Our ref: NO/2017/109749/01-L01
Your ref: 3/2017/0270
Date: 12 April 2017

**CREATION OF NEW VEHICULAR AND PEDESTRIAN ACCESS AND AREA OF
ADDITIONAL CAR PARKING ASSOCIATED WITH THE ADJACENT HOLMES MILL
DEVELOPMENT**

62 MOOR LANE, CLITHEROE, BB7 1AJ

drg.no. 14/59 PL01 rev. G

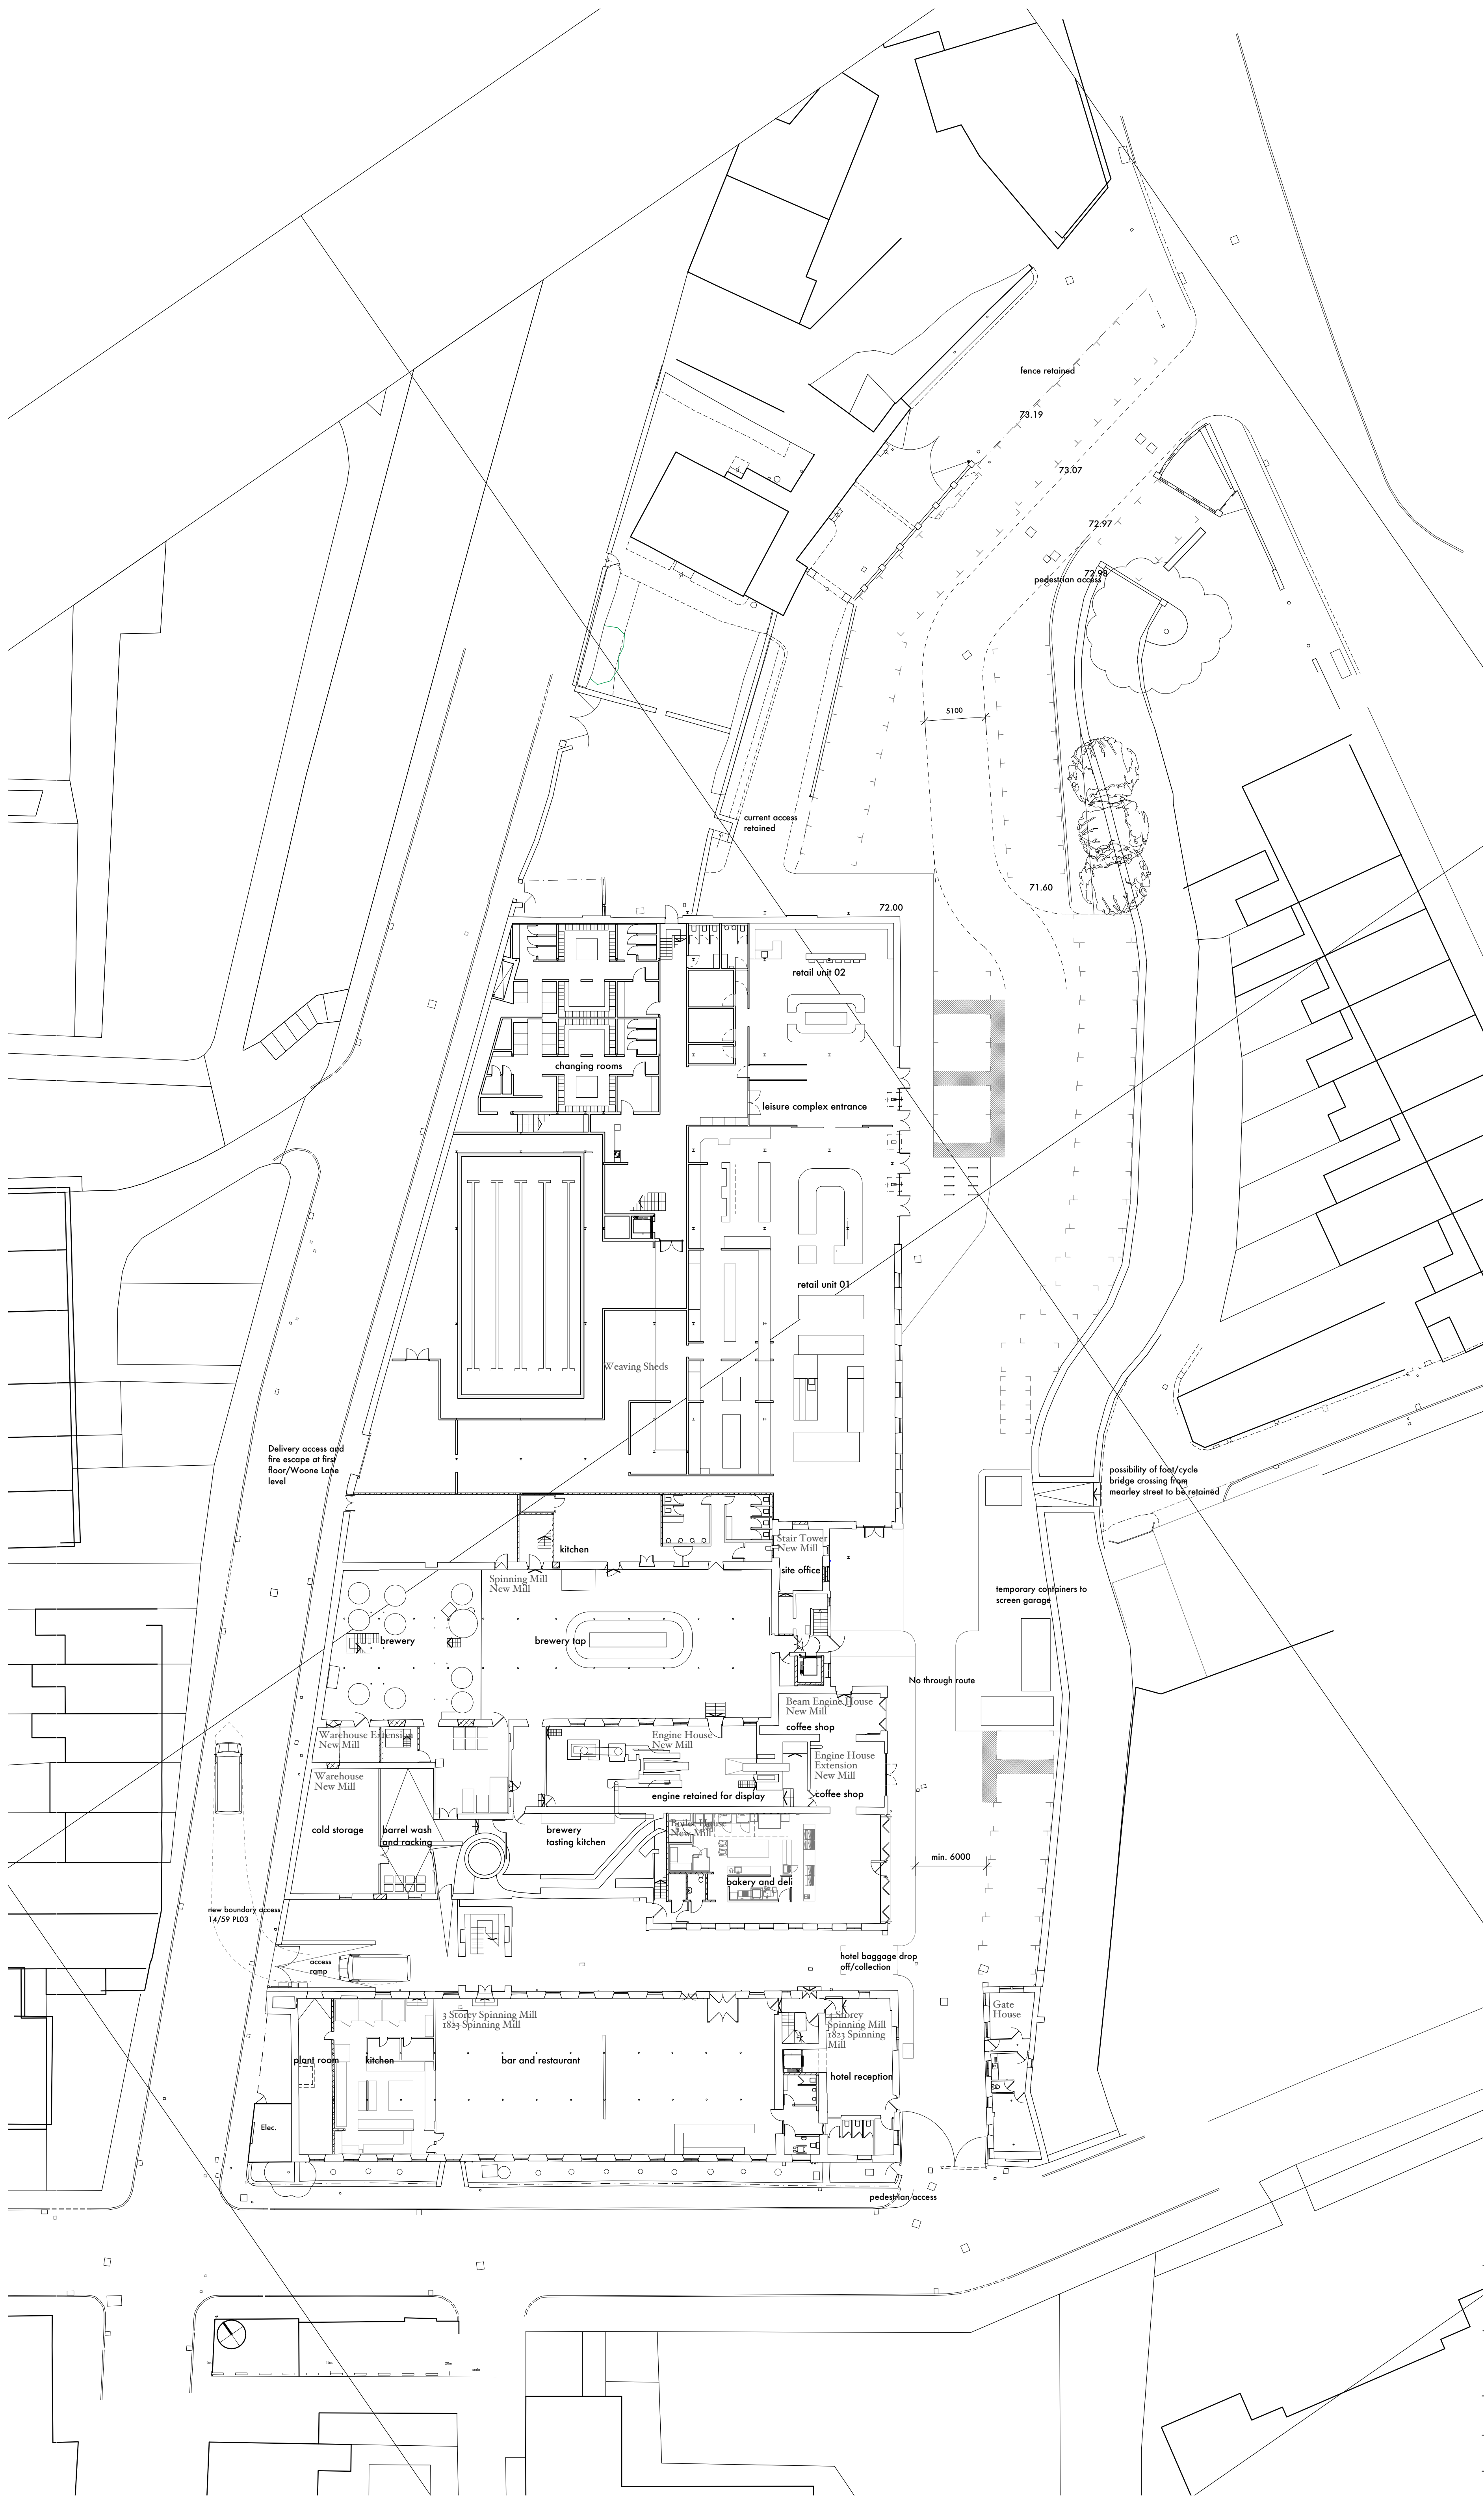
In particular, the application proposes to alter a structure that retains flood water. A detailed hydraulic model would be needed to fully understand the effect on flood risk to the site and the surrounding area.

Mearley Brook adjacent to the application site is designated a Main River. As such, any

works within 8 metres from the top of the bank/retaining wall requires an Environmental Permit under the Environmental Permitting Regulations. Any activities which may increase flood risk would not be issued an Environmental Permit

Mearley Brook adjacent to the site is designated a Main River and the developer may need an Environmental Permit. In particular, no trees or shrubs may be planted, nor fences, buildings, pipelines or any other structure erected within 8 metres of the top of any bank/retaining wall of the Main River watercourse without an Environmental Permit. The developer should check at <https://www.gov.uk/guidance/flood-risk-activities-environmental-permits> and contact Flood Risk Officer, James Jackson, on 020 302 51306 to discuss our requirements if a permit or advice is required.

You can overcome our objection by submitting a FRA which covers the deficiencies highlighted above and demonstrates that the development will not increase risk elsewhere and where possible reduces flood risk overall. If this cannot be achieved we are likely to maintain our objection to the application. Production of a FRA will not in itself result in the removal of an objection.
